From: Laura Gibbons
Sent: 20 June 2019 09:52
To: Planning.Responses
Cc: Zac Denton
Subject: RE: Planning Consultation on: CM/18/19/PL

Engineers Comments Regarding Surface Water Drainage

APPLICATION **CM/18/19/PL**

Description of Works: Erection of 2 No 3 bed dwellings with off-road parking and
associated landscaping

drawing title:
Site Plan

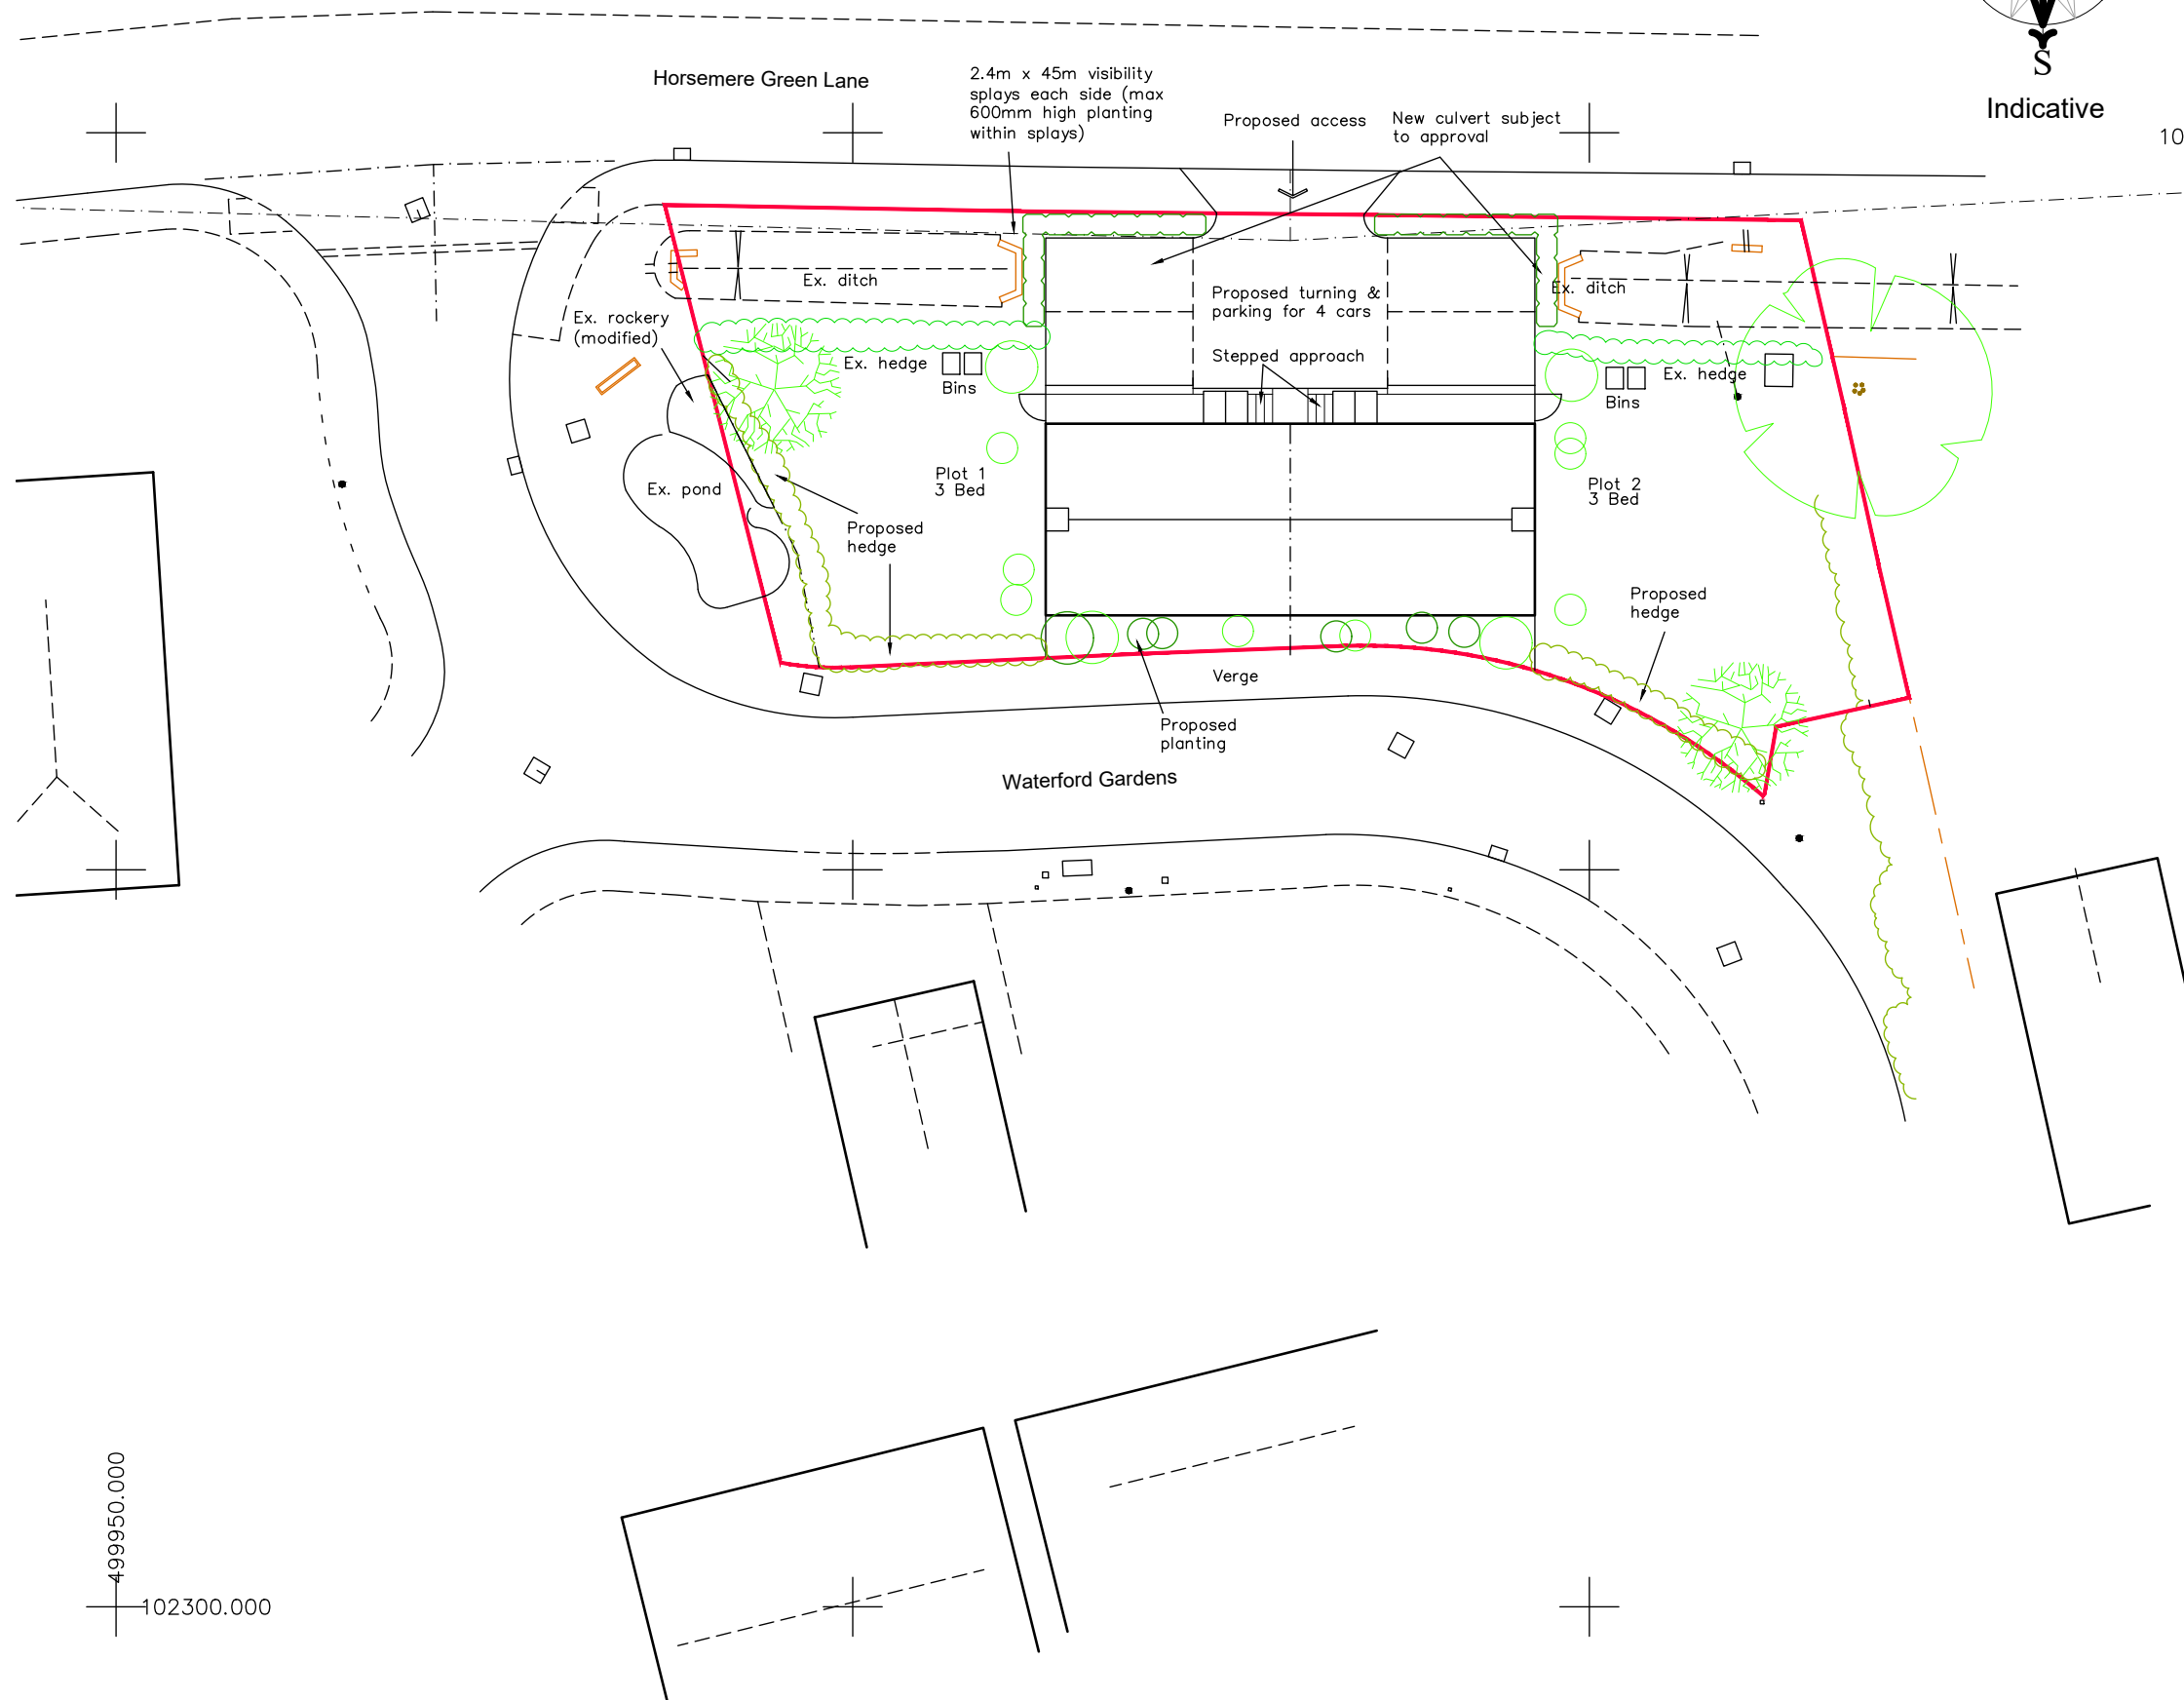
Some detail has been provided of the surface water drainage proposals which are based on infiltration testing. However, it is not clear at what time of year, or depth this testing was completed. No winter groundwater monitoring results have been provided.

The surface water drainage layouts also show soakaways in very close proximity to the red line boundary and ditch. This could destabilise the ditch. There should be 5m between proposed soakaways and buildings, and 2.5m to property boundaries. Details of root protection zones would also need to be submitted to ensure no conflict with the proposals.

A new access way is proposed to be formed. This would involve culverting an ordinary watercourse, consent would be required for this.

"Development shall not commence, other than works of site survey and investigation, until full details of the proposed surface water drainage scheme have been submitted to and approved in writing by the Local Planning Authority. The design should follow the hierarchy of preference for different types of surface water drainage disposal systems as set out in Approved Document H of the Building Regulations, and the recommendations of the SuDS Manual produced by CIRIA. Winter groundwater monitoring to establish highest annual ground water levels and winter Percolation testing to BRE 365, or similar approved, will be required to support the design of any Infiltration drainage. No building / No part of the extended building shall be occupied until the complete surface water drainage system serving the property has been implemented in accordance with the agreed details and the details so agreed shall be maintained in good working order in perpetuity."

"The development shall not proceed until details have been submitted to and approved in writing by the Local Planning Authority for any proposals: to discharge flows to watercourses; or for the culverting, diversion, infilling or obstruction of any watercourse on or adjacent to the site. Any discharge to a watercourse must be at a rate no greater than the pre-development run-off values. No construction is permitted, which will restrict current and future land owners from undertaking their riparian maintenance responsibilities in respect to any watercourse or culvert on or adjacent to the site."

"Infiltration rates for soakage structures are to be based on percolation tests undertaken in the winter period and at the location and depth of the proposed structures. The percolation tests must be carried out in accordance with BRE365, CIRIA R156 or a similar approved method and cater for the 1 in 10 year storm between the invert of the entry pipe to the soakaway, and the base of the structure. It must also have provision to ensure that there is capacity in the system to contain below ground level the 1 in 100 year event plus 40% on stored volumes, as an allowance for climate change. Adequate freeboard must be provided between the base of the soakaway structure and the highest recorded annual groundwater level identified in that location. Any SuDS or soakaway design must include adequate groundwater monitoring data to determine the highest winter groundwater table in support of the design. The applicant is advised to discuss the extent of groundwater monitoring with the Council's Engineers. Supplementary guidance notes regarding surface water drainage are located here <https://www.arun.gov.uk/surfacewater> on Arun District Councils website. A surface water drainage checklist is available here <https://www.arun.gov.uk/drainagechecklist> on Arun District Councils website, this should be submitted with a Discharge of Conditions Application."

The development layout must take account of any existing watercourses (open or culverted) to ensure that future access for maintenance is not restricted. No development is permitted within 3m of the bank of an ordinary watercourse, or 3m of a culverted ordinary watercourse.
